Recommendation Report for Planning Permission for Works or Extension to a Dwelling

REF NO: FP/185/25/HH

LOCATION: 25 Kingsmead
Felpham
PO22 7BD

PROPOSAL: Single storey rear extension following demolition of existing extension.

Proposed Ground Floor Plan Scale 1:50

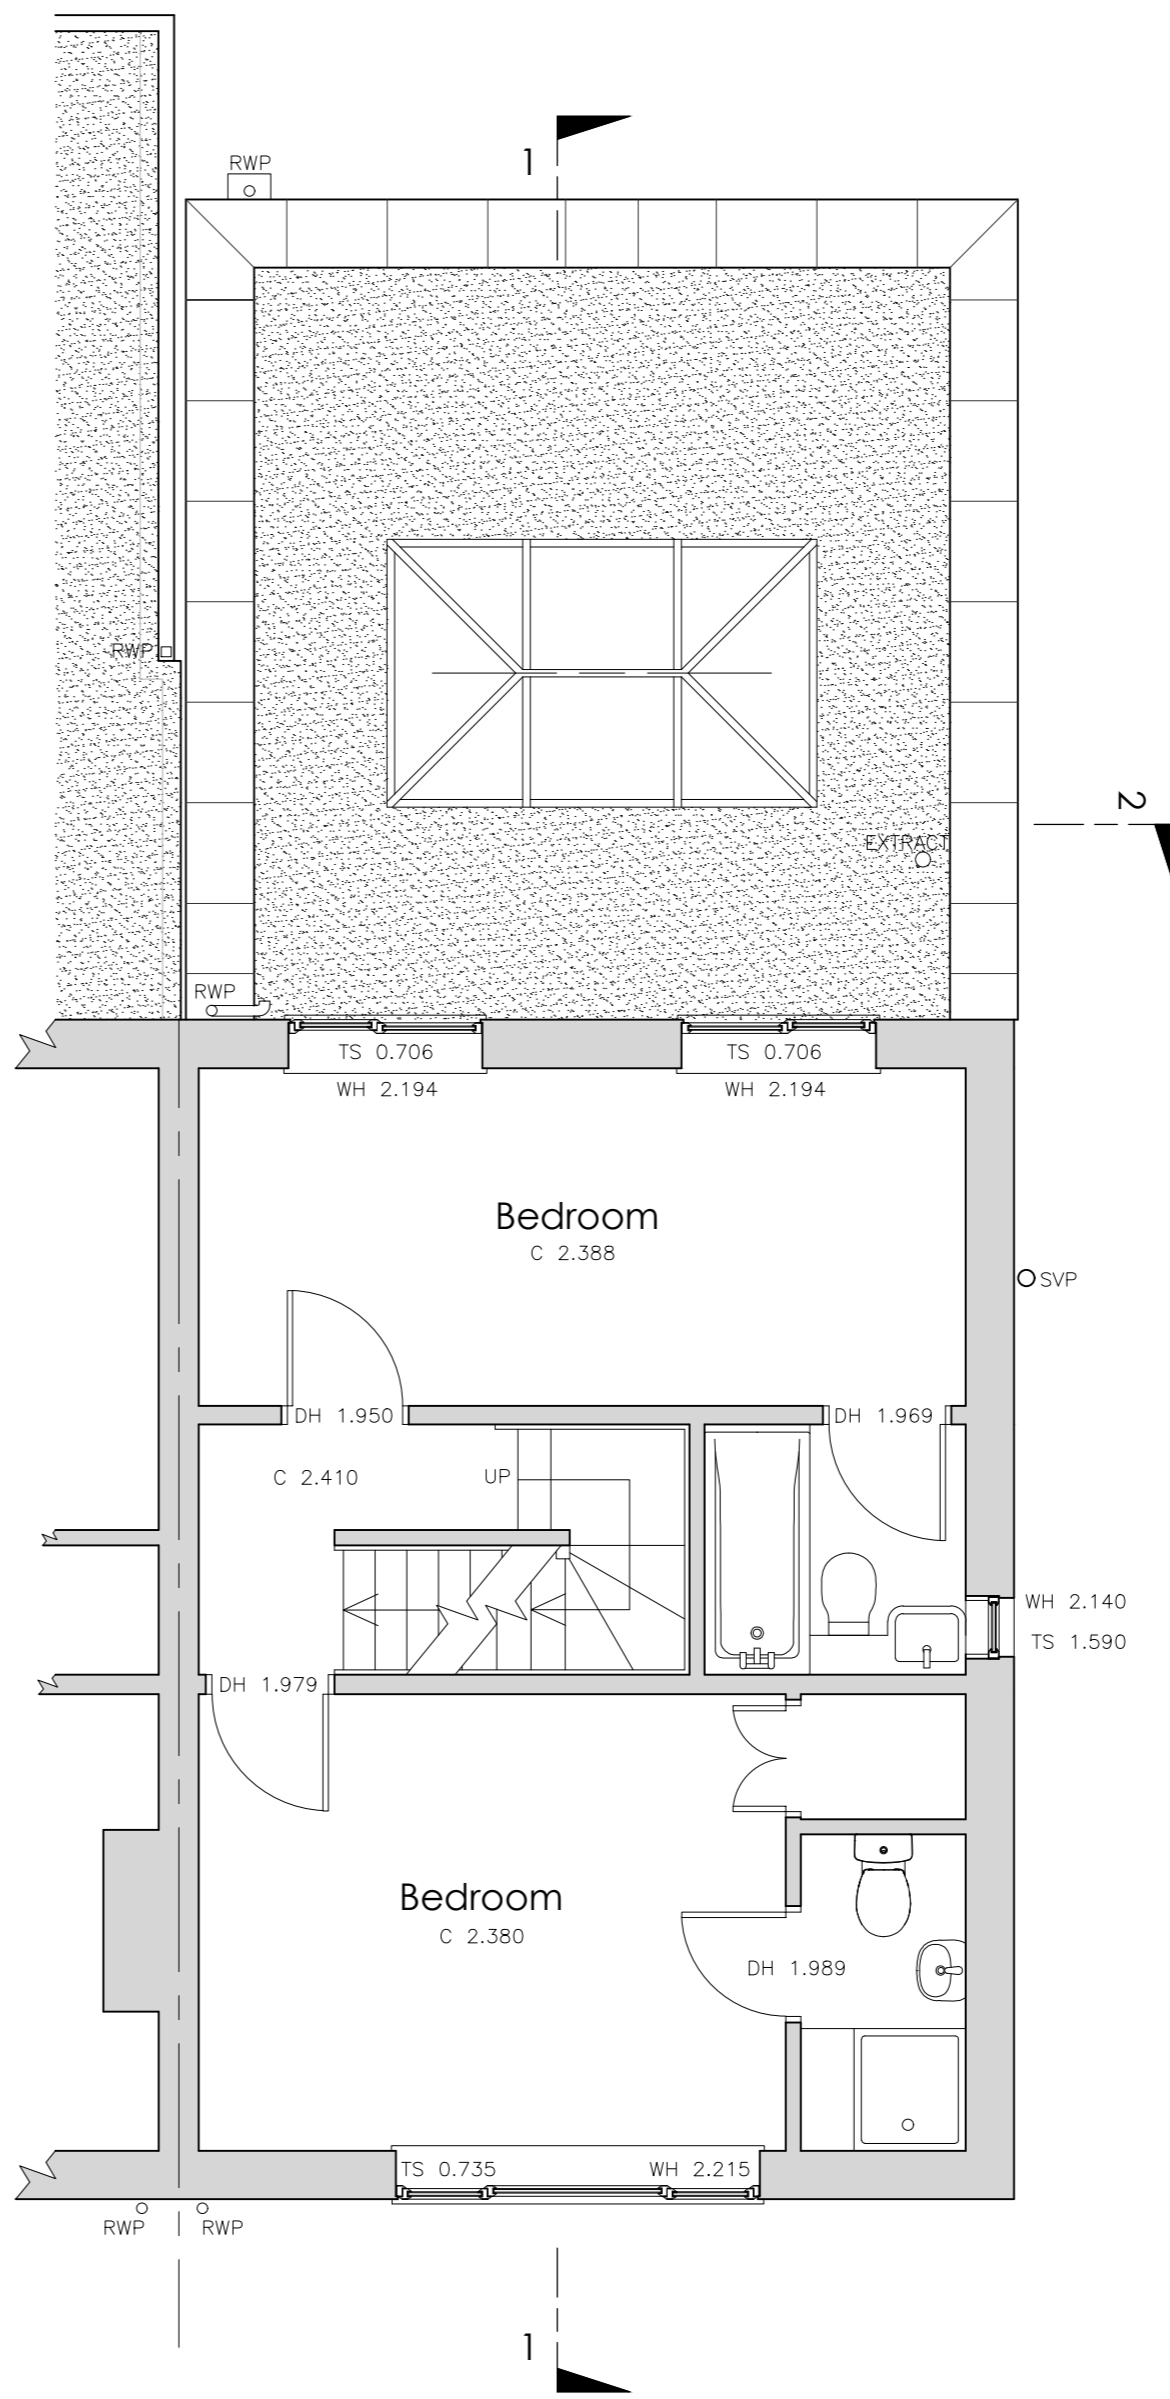
The single storey rear extension would have a width of 5.5m, equal to the existing width of the host dwelling, and would have a depth of 5.4m. It is noted that the extension would exceed the 3.3m guidance depth for rear extension to semi-detached dwellings outlined in the Arun Design Guide (ADG); however, given the siting of the extension at 23 Kingsmead (the neighbour to the east), and the remaining rear garden depth of 17.5m (which complies with the ADG), the proposed rear extension would not result in harm to visual amenity.

A new door, in the same location, is proposed on the western flank of the host dwelling. The window adjacent to this is proposed to be replaced by a smaller window of the same height but lesser width.

The extension would be finished with painted render to match the existing property. The parapet walls would feature stone copping and the fenestrations would be black aluminium heritage style windows and doors, which would include a window and door on the western flank of the extension and double doors with full-length windows on either side. Arun Local Plan policy D DM1 states that a high standard of building materials and design features should be used in developments where possible. The proposed material palette would make a positive contribution to the design and visual amenity of the locality and is therefore in accordance with Arun Local Plan policies D DM1 and D DM4.

The current rear extension is set in by approximately 0.1m from the shared boundary with 23 Kingsmead; this distance would be maintained by the replacement extension. The extension would not protrude beyond the existing rear building line at 23 Kingsmead. The parapet walls, which would be approximately 0.5m higher than the roof of the neighbouring extension, may have some overbearing effects. However, considering the existing siting and scale of the extension at 23 Kingsmead, the proposed extension would not result in significant harm by way of overbearing or overshadowing impacts to this neighbour.

The proposed extension would have a width equal to the host dwelling and would therefore maintain a distance of 1.7m to the shared boundary with 27 Kingsmead, to the west, and 2.8m to the eastern flank of 27 Kingsmead, respectively. The extension would comply with the 45-degree rule, as described by the Arun Design Guide. The proposed extension would be approximately 1.5m higher than the boundary treatment separating 25 and 27 Kingsmead, however, given the space maintained between the dwellings and the orientation of the host dwelling, which is angled away from 27 Kingsmead, the proposal would

The fenestration proposed and amended would provide an outlook of the rear amenity area and the side passage which runs along the western flank of the site. Views from the proposed extension would currently be achievable from the rear amenity area and would not result in harm by way of overlooking to the neighbouring dwellings.

Proposed Roof Plan Scale 1:50

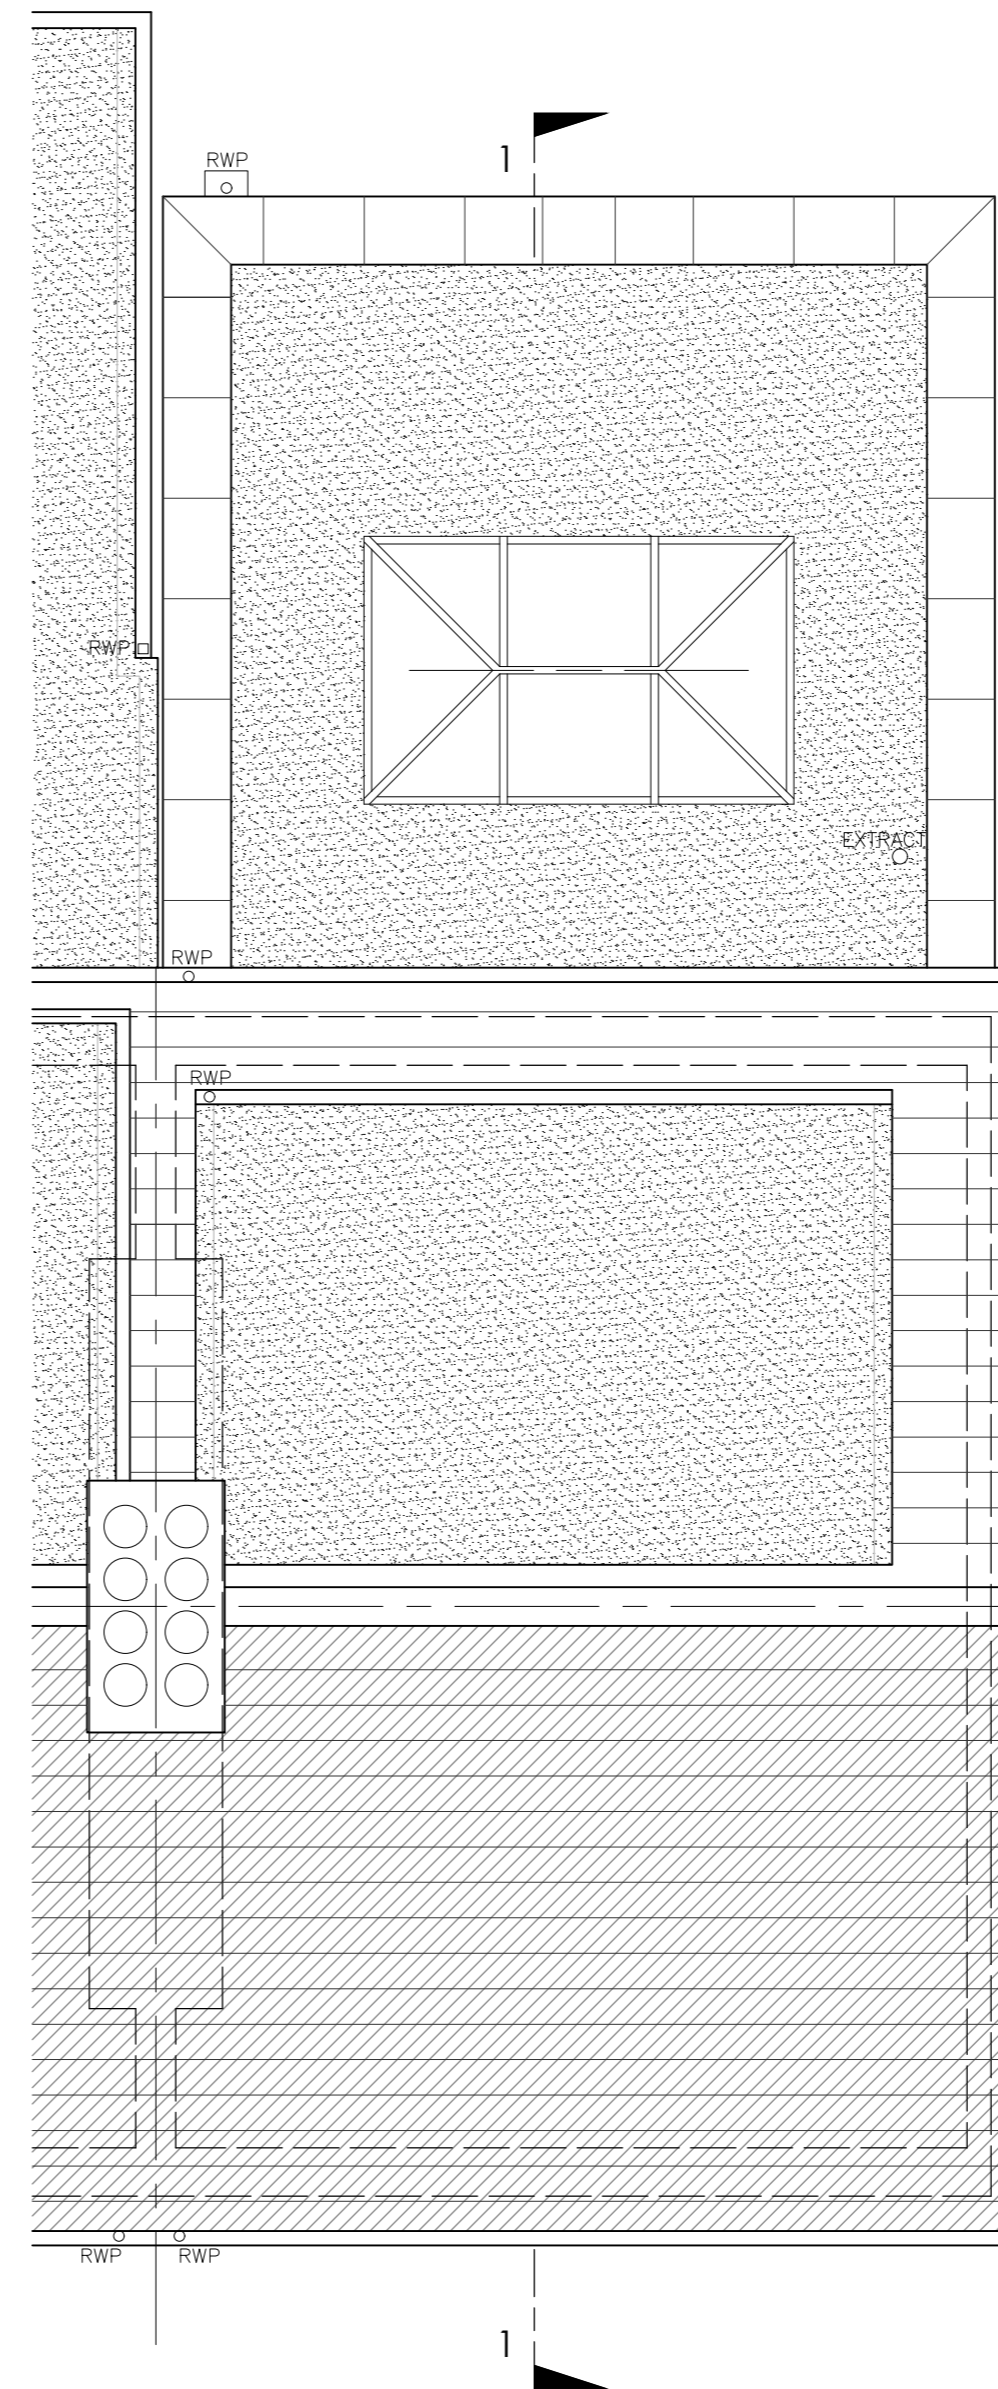
The extension would have a flat roof, at a height of 3.45m including parapet walls (approximately 0.5m higher than the existing extension) and incorporate a roof lantern. Flat roof extensions and roof lanterns/lights are consistent architectural features along Kingsmead.
